Planning and Regulatory. G.Mansfield
Reference: PB2015/00161
Phone: 02 4974 2767

28 October 2015

NOTIFICATION OF MODIFICATION REQUEST NEWCASTLE PRIVATE HOSPITAL -2 &14 LOOKOUT ROAD NEW LAMBTON HEIGHTS

I refer to the Department's letter of 2 October 2015 advising that Healthscope Operations Pty Ltd has submitted a request (08_0170 MOD 2) to further modify the approval granted in 2009 for the Newcastle Private Hospital Project.

Drawing: BASEMENT LEVEL B2 PLAN - EXTENSION

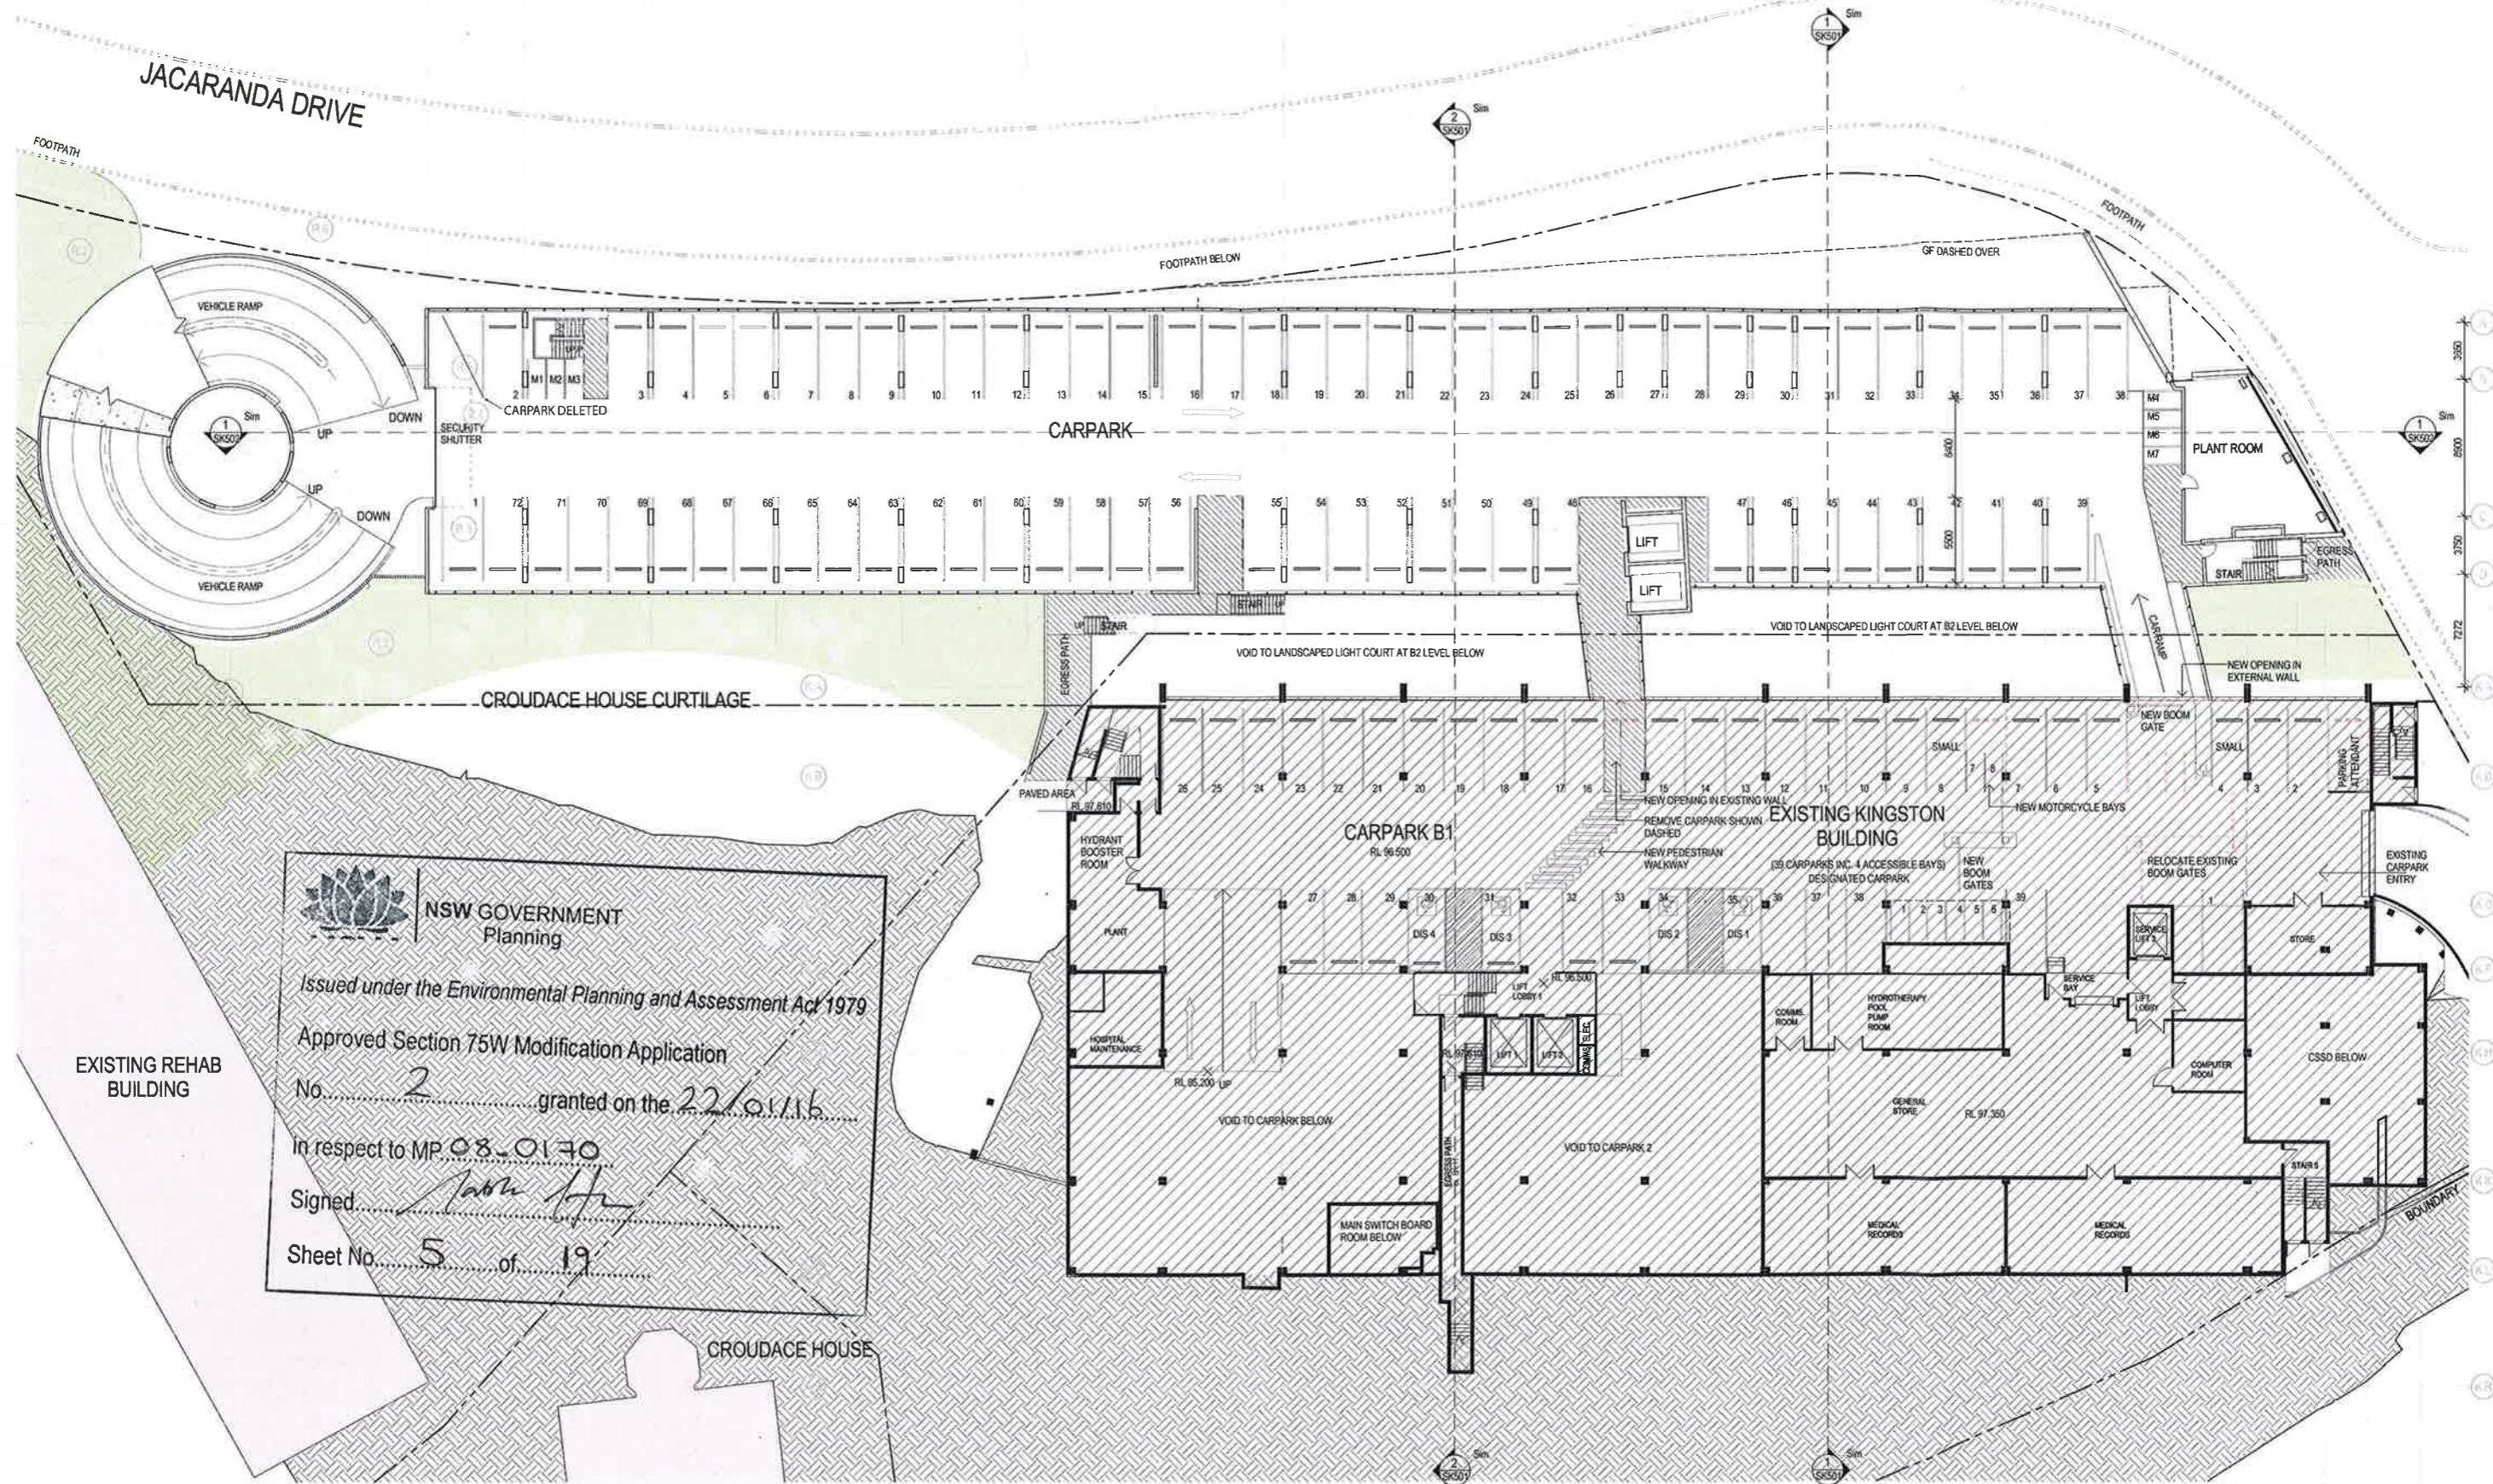
Council's previous submission of 24 July, 2009 raised safety concerns in the relation to the proximity of proposed parking spaces to the access ramps at each level in the parking station. Driver sight lines are considered to be compromised thereby

increasing the potential for vehicle conflict. This issue has not been addressed by the traffic consultant's report and needs to be reviewed and resolved prior to the determination of the modification request.
